CITY OF PORTLAND, MAINE  
PLANNING BOARD

March 14, 2002

RE: Site Plan Re-Approval of Industrial Building, 941 Riverside Street  
ID #2002-0054, CBL #329-B-006

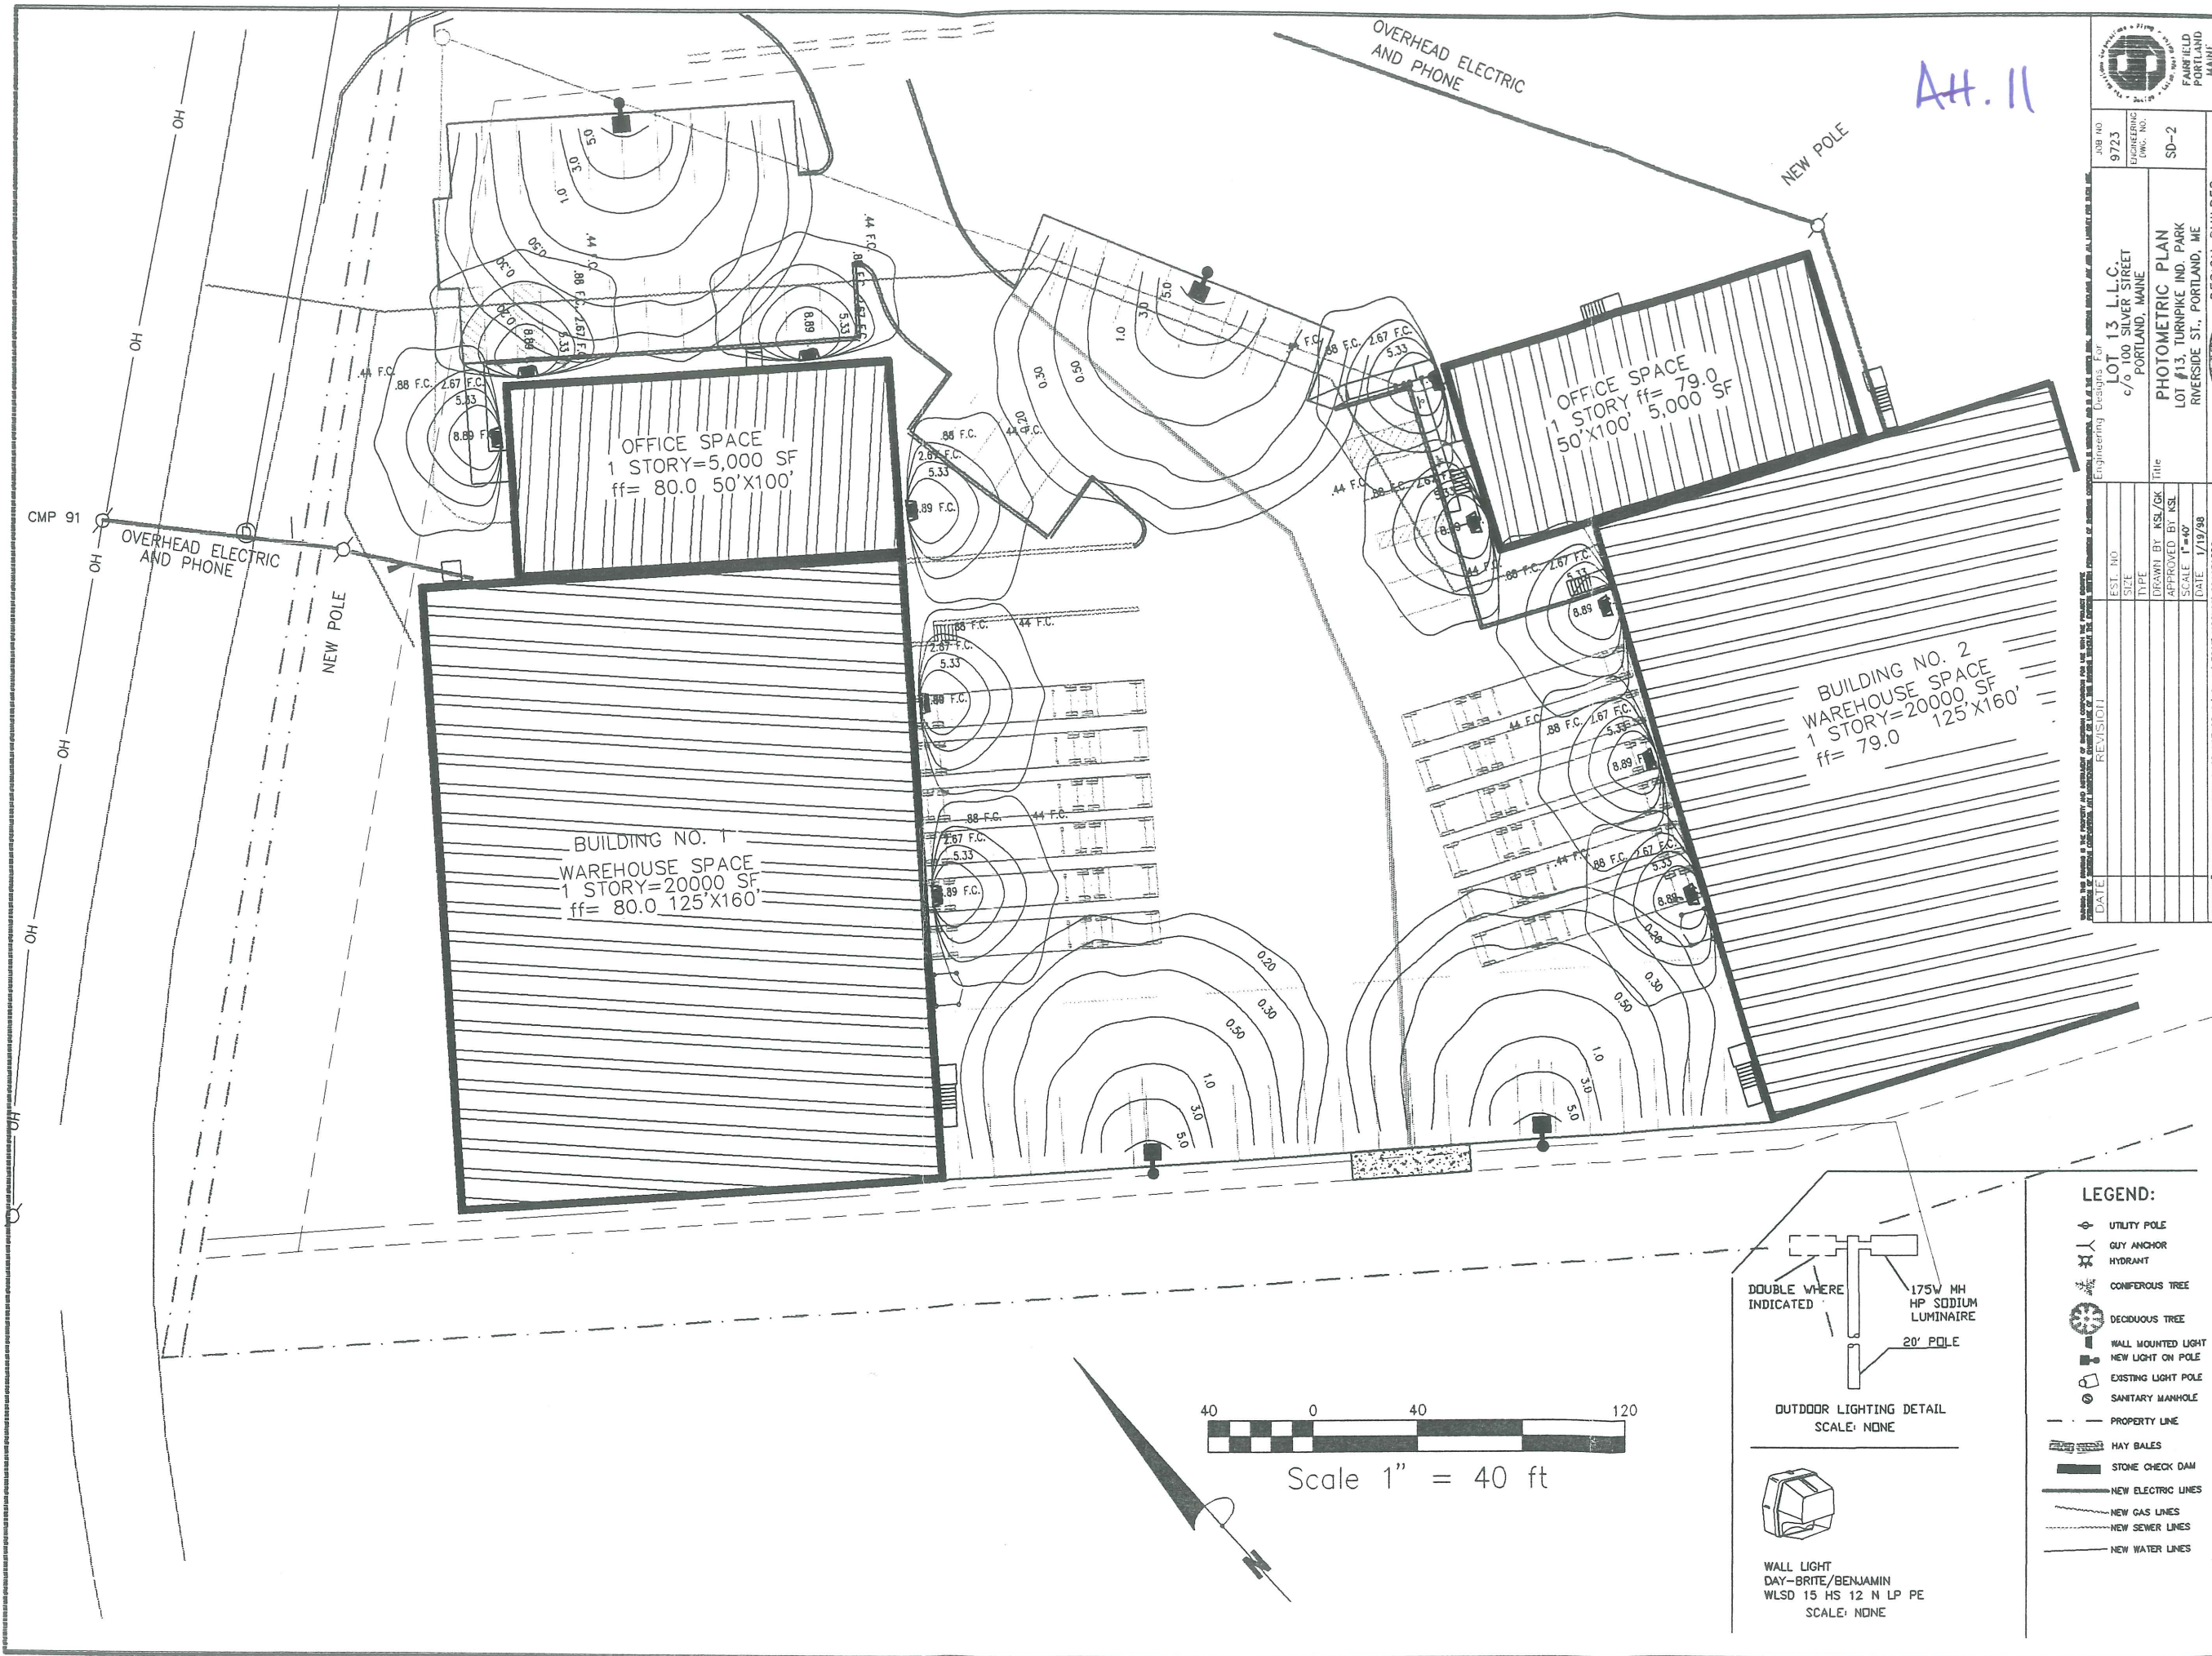
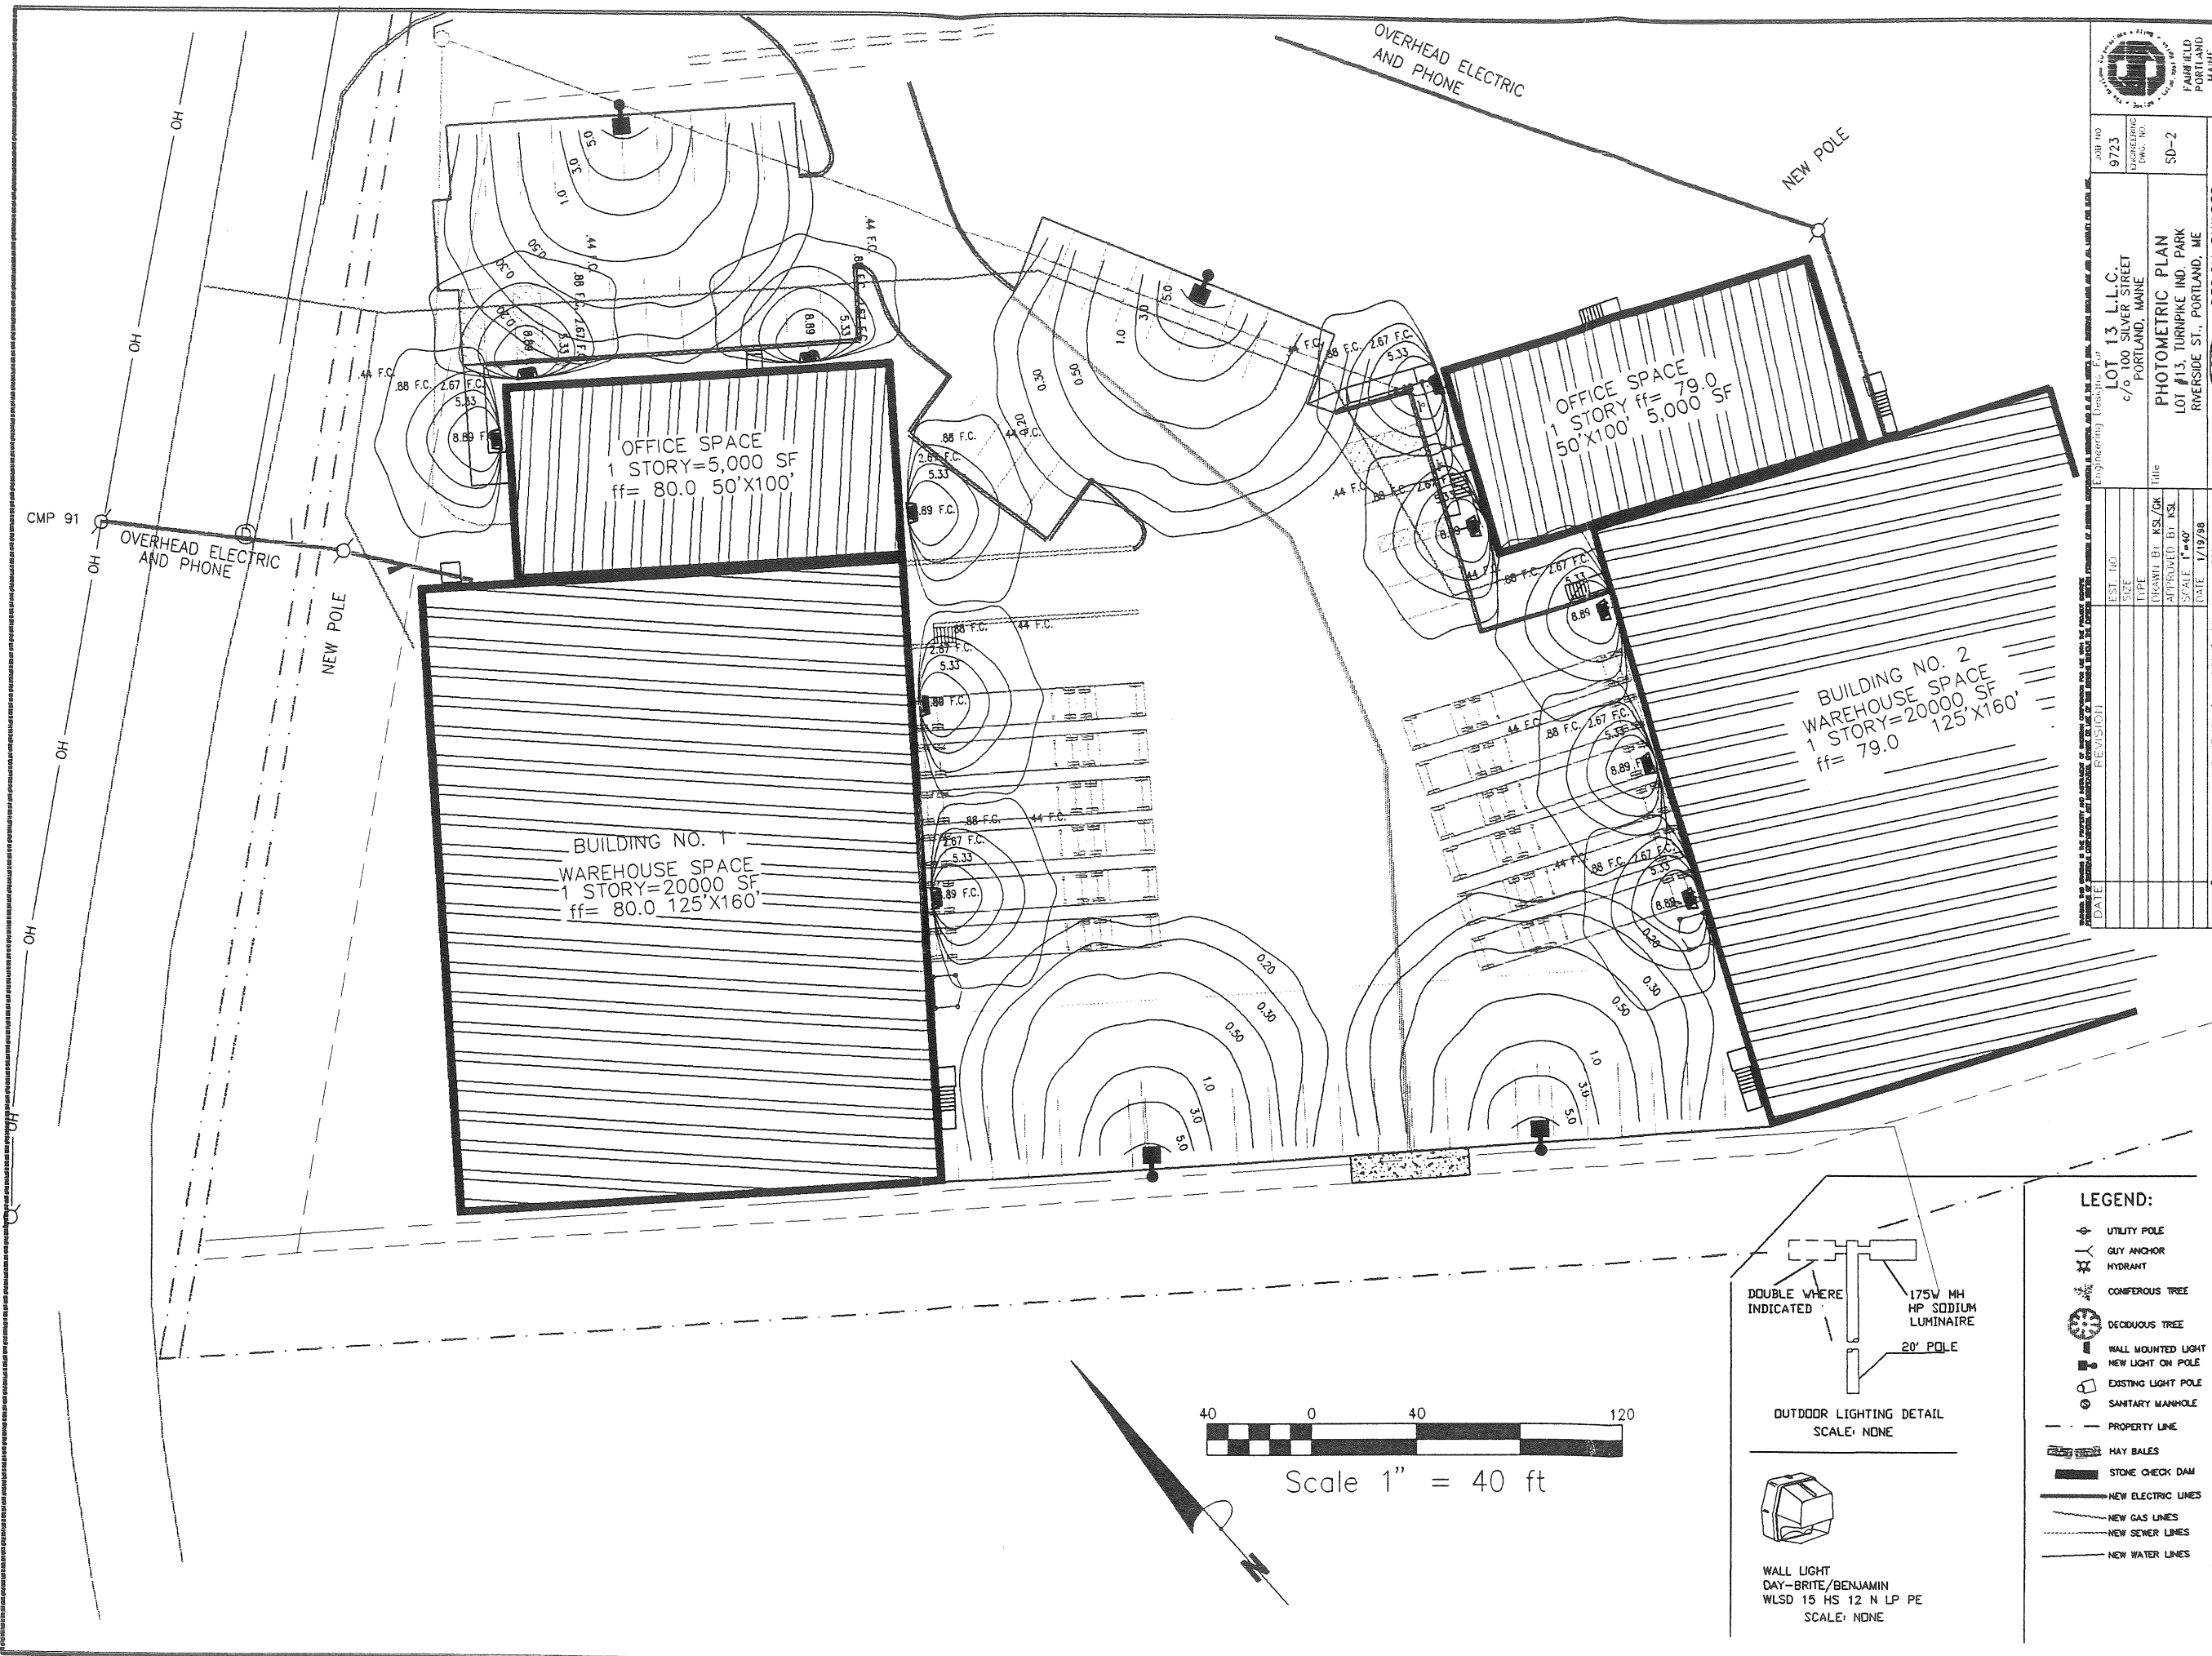
- i. That the applicant repair the existing stone check dams and that the riprap outlet be installed as proposed.
- ii. That the applicant proposed a wall pack light fixture that is a "cut-off" type to be reviewed and approved by staff.
